Our Ref: R/2016/1/D
File No: MP 08_0098 MOD 13

The Star (MP08_0098 MOD 13) – 20-80 Pyrmont Street, Pyrmont – Response to Submissions

The City of Sydney (the City) has reviewed the RTS and maintains its **objection** as the issues raised in the City's letter dated 9 October 2018 remain unaddressed. The following additional comments are provided for your consideration:

Section 15 Ribbon

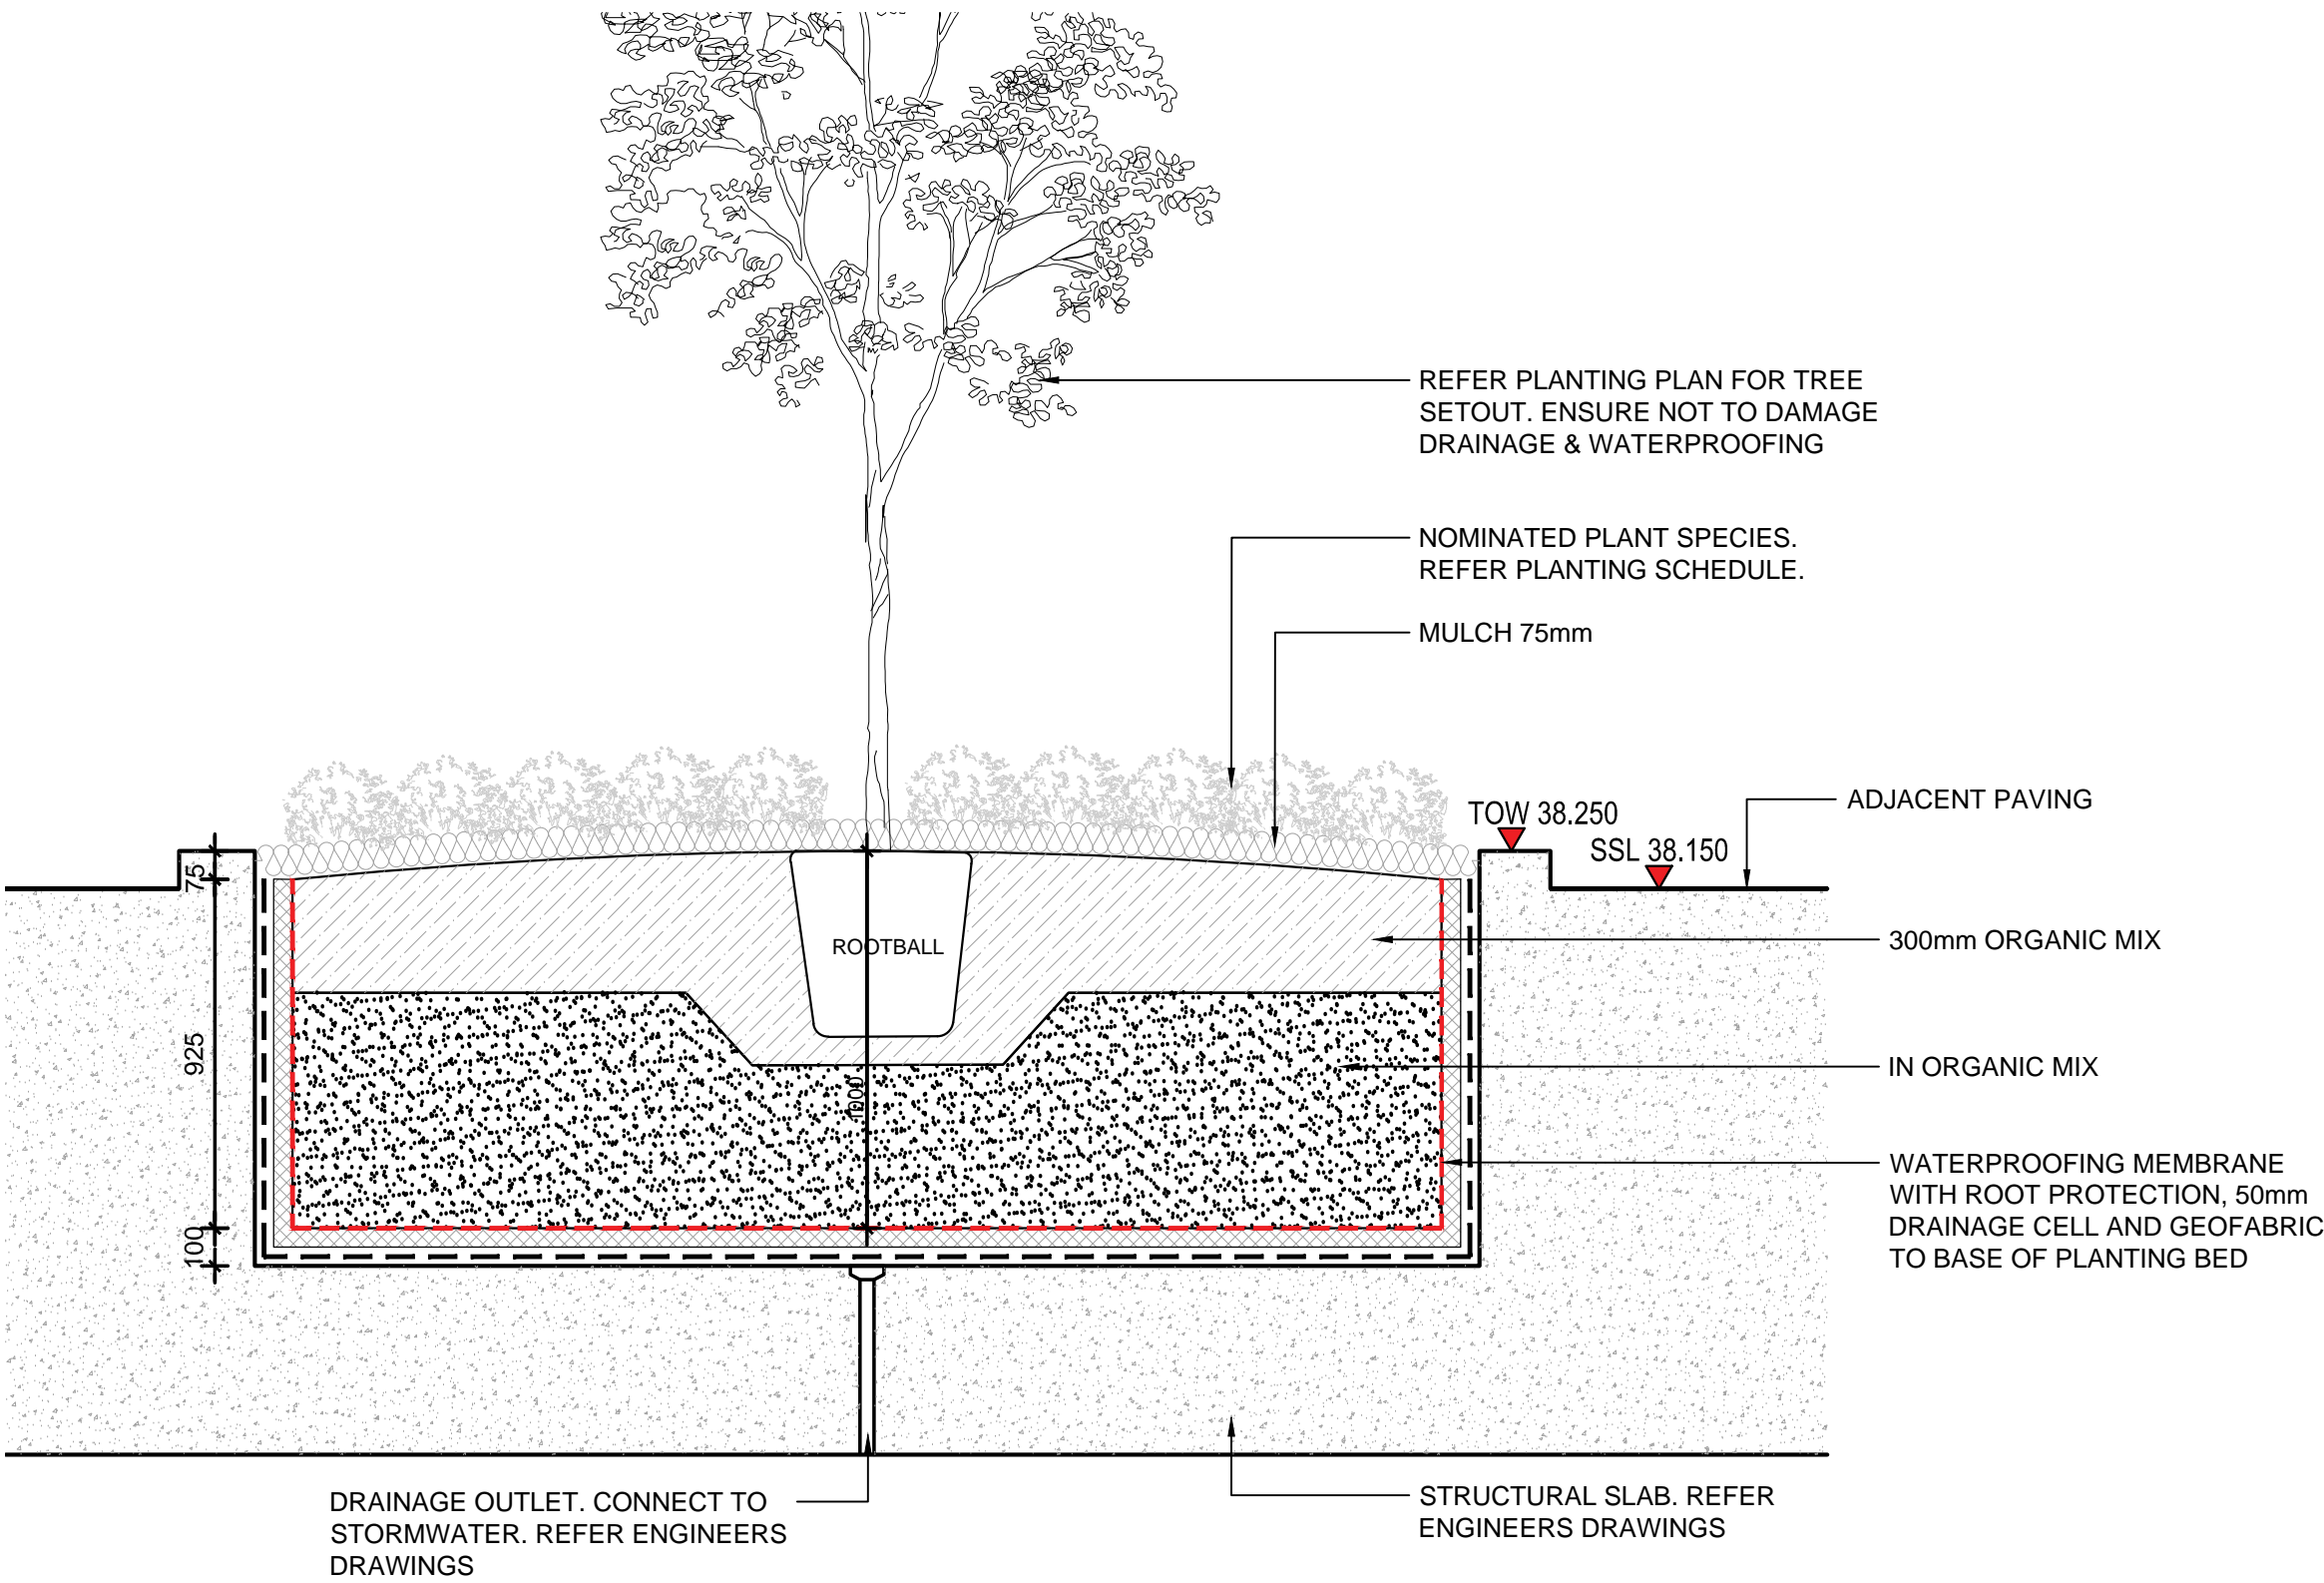
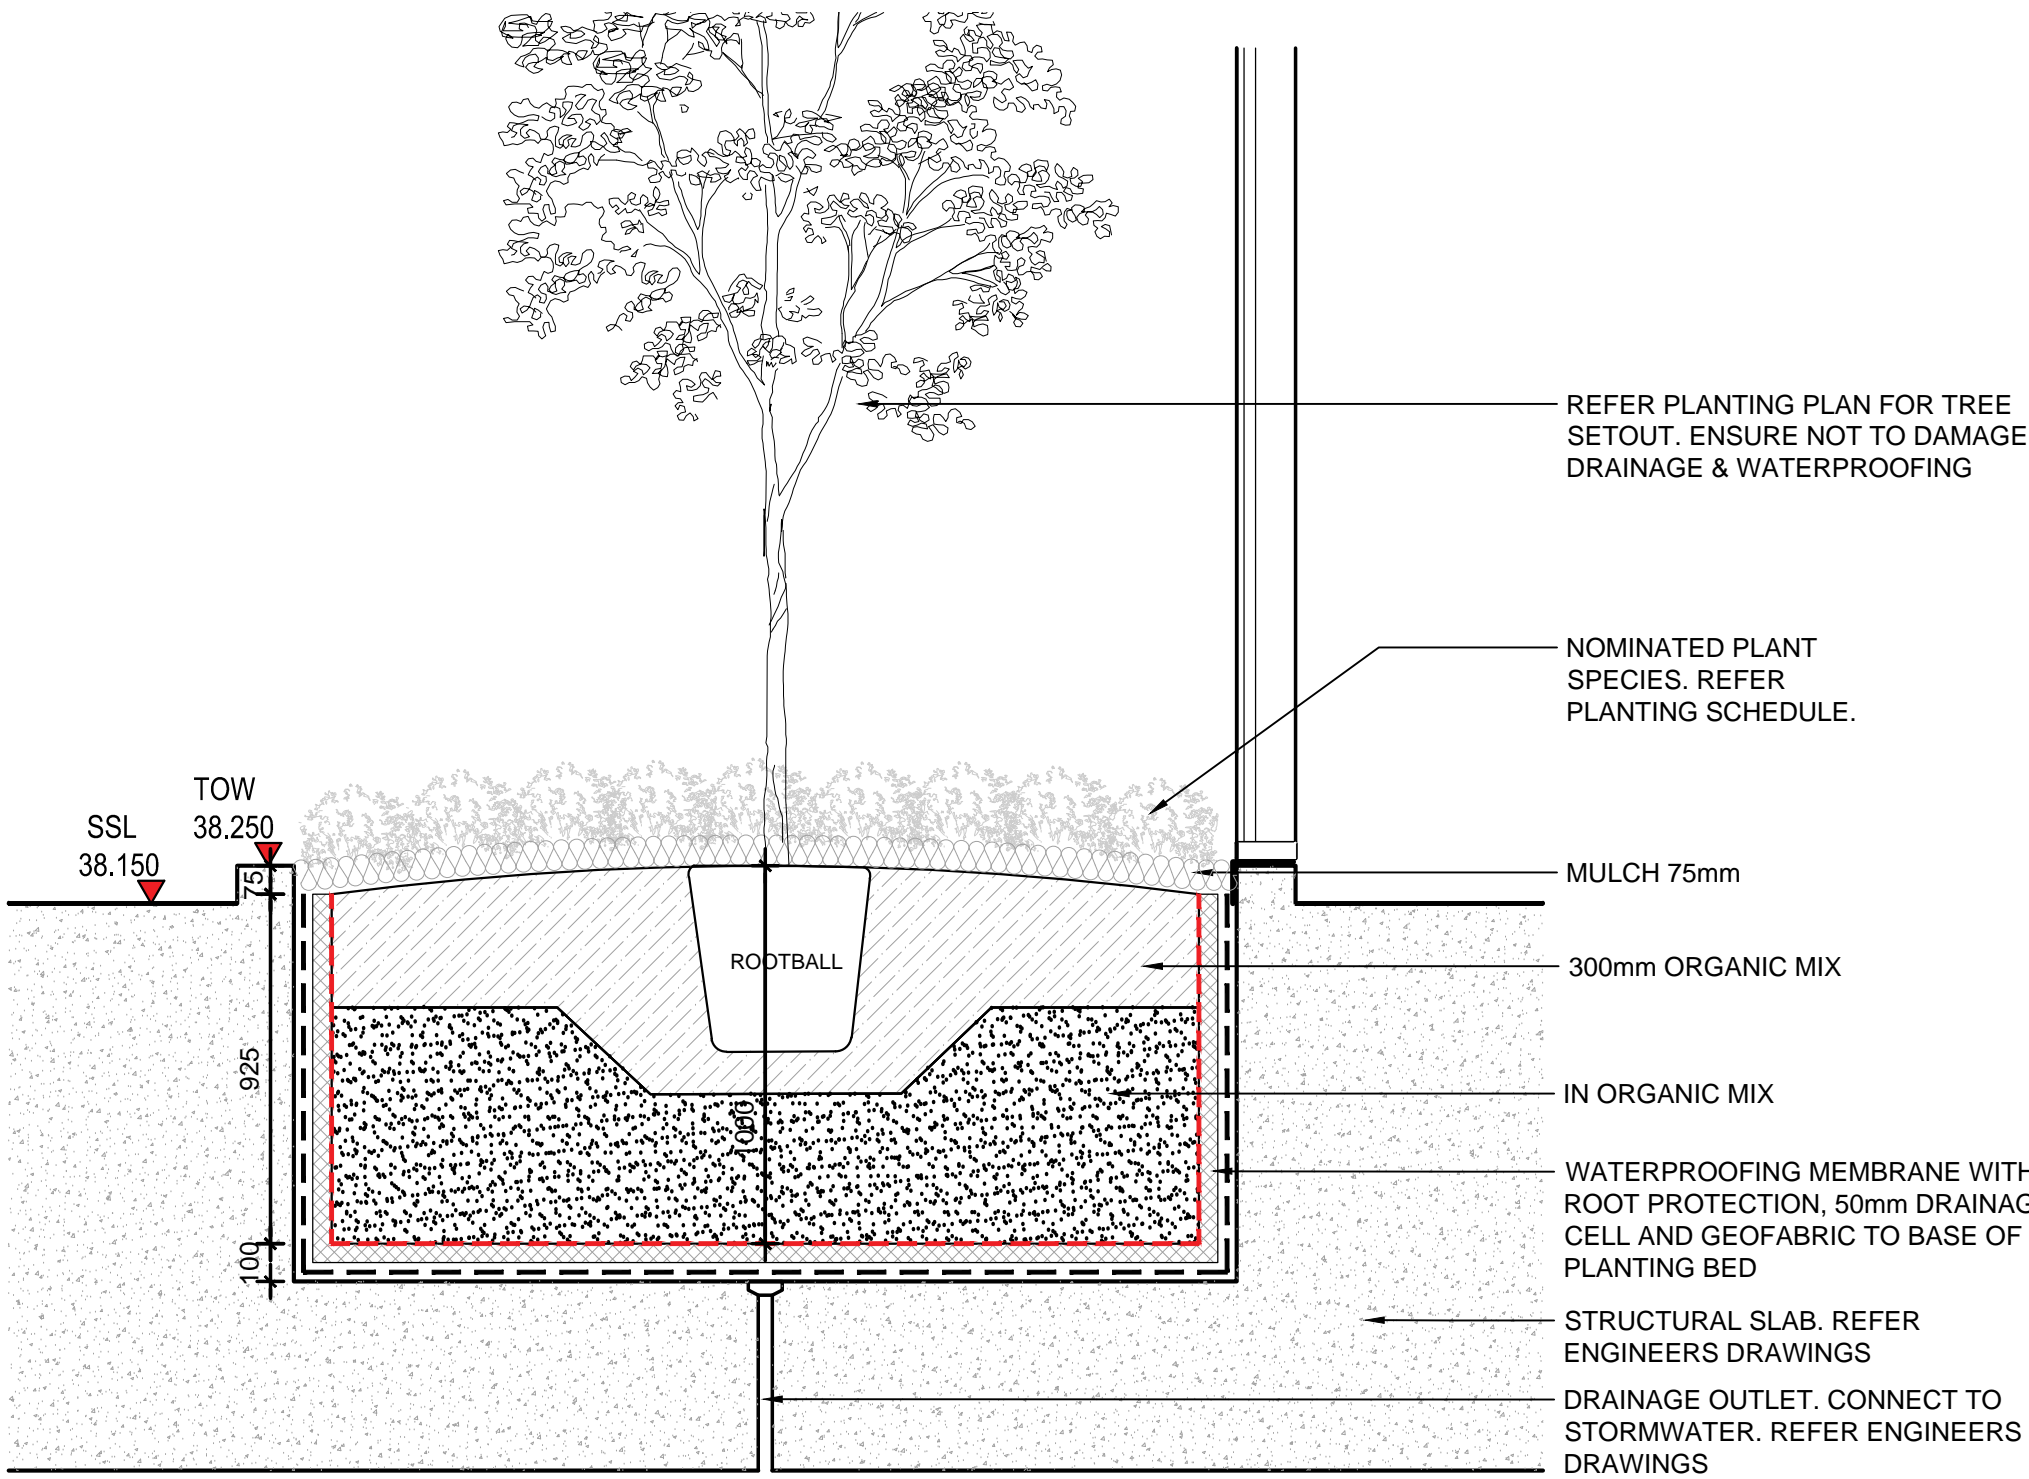
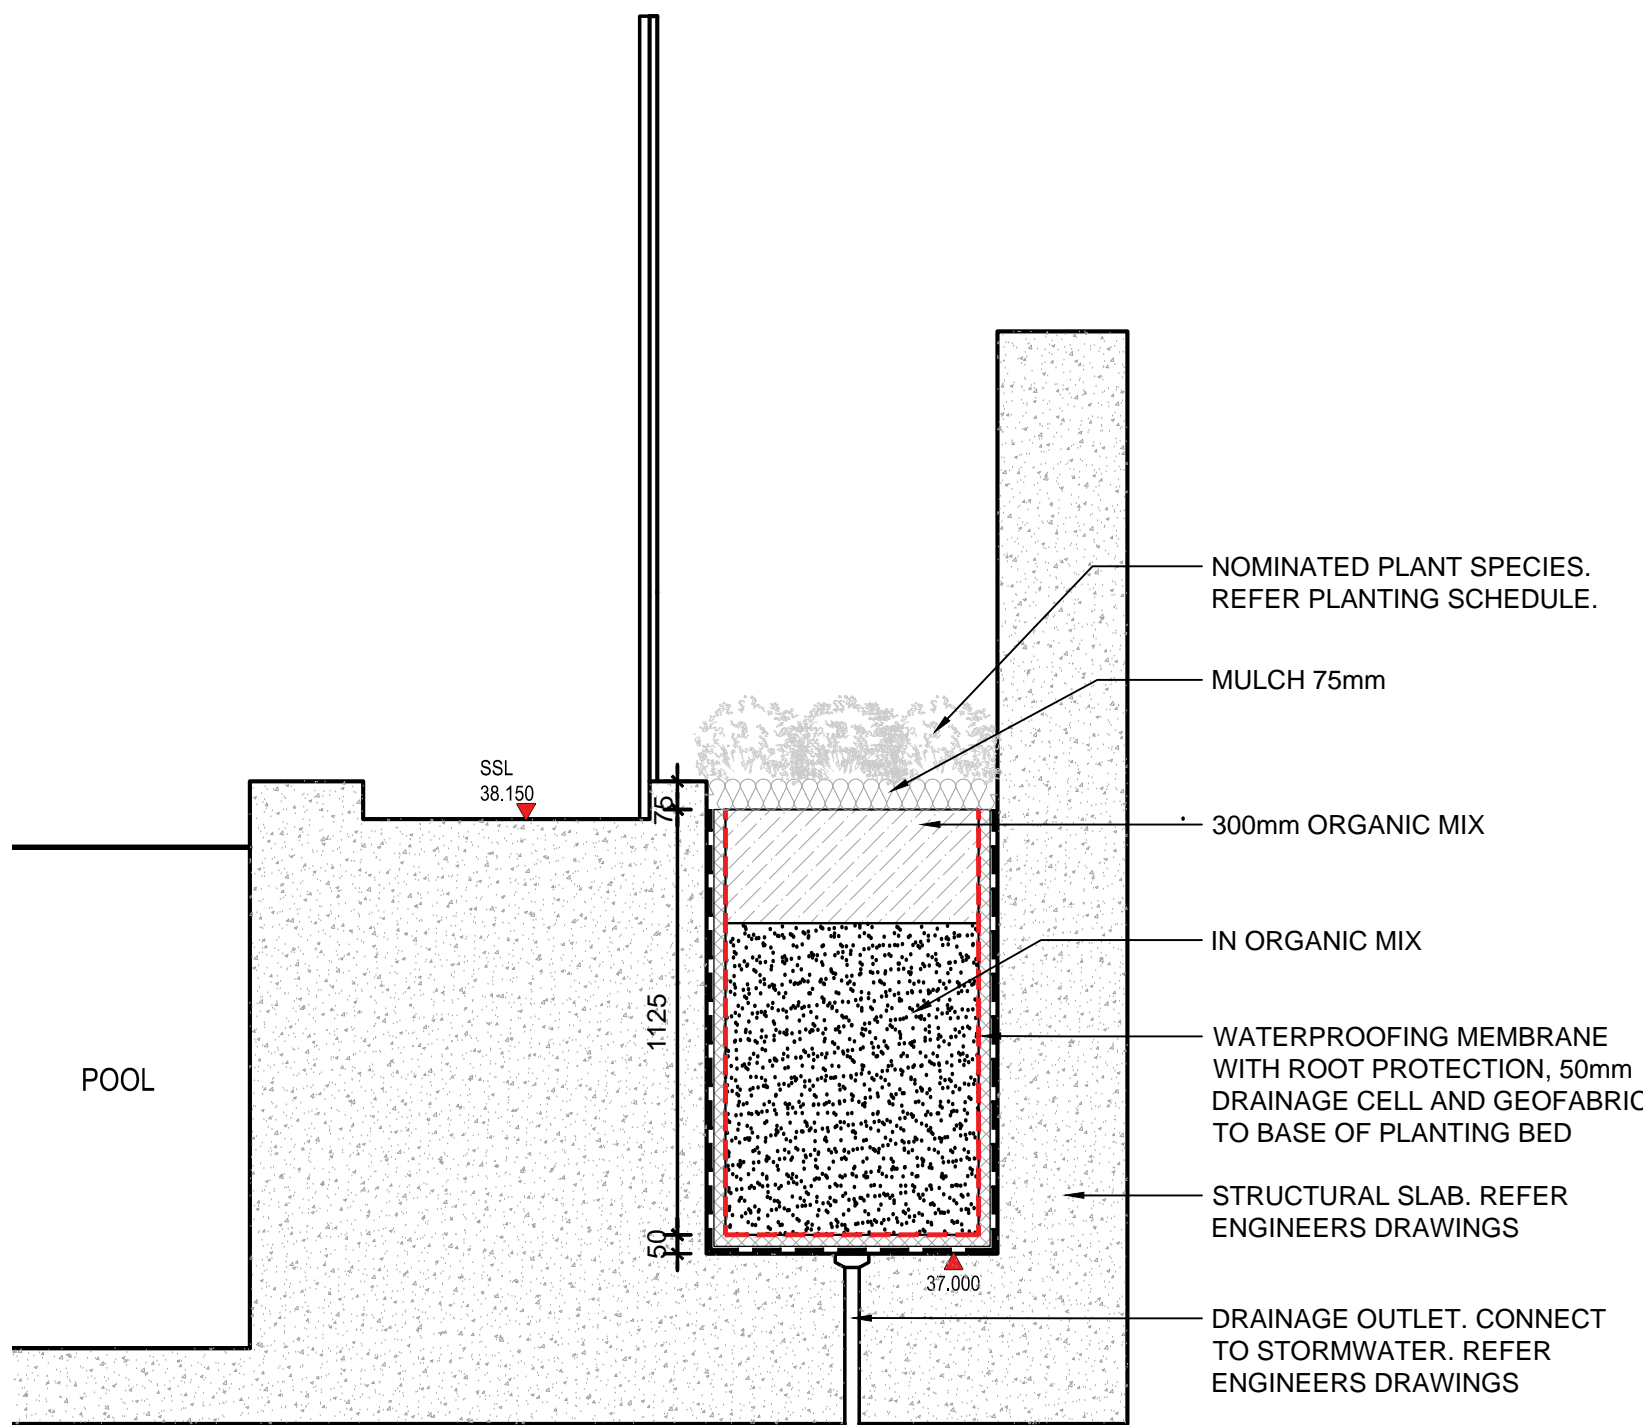
The applicant has confirmed minimum soil depths will be in accordance with the Landscape Code Volume 2 and the ADG as noted in table below, which is supported. However, several typical planter sections for planting on podium shown on Dwgs L900-902 [A], do not reflect the minimum depths which is not supported.

It is recommended that the landscape design should ensure that minimum soil depths (or higher) are achieved to ensure a high quality landscape outcome. It is noted that the minimum soil depths are in addition to drainage and mulch layers.
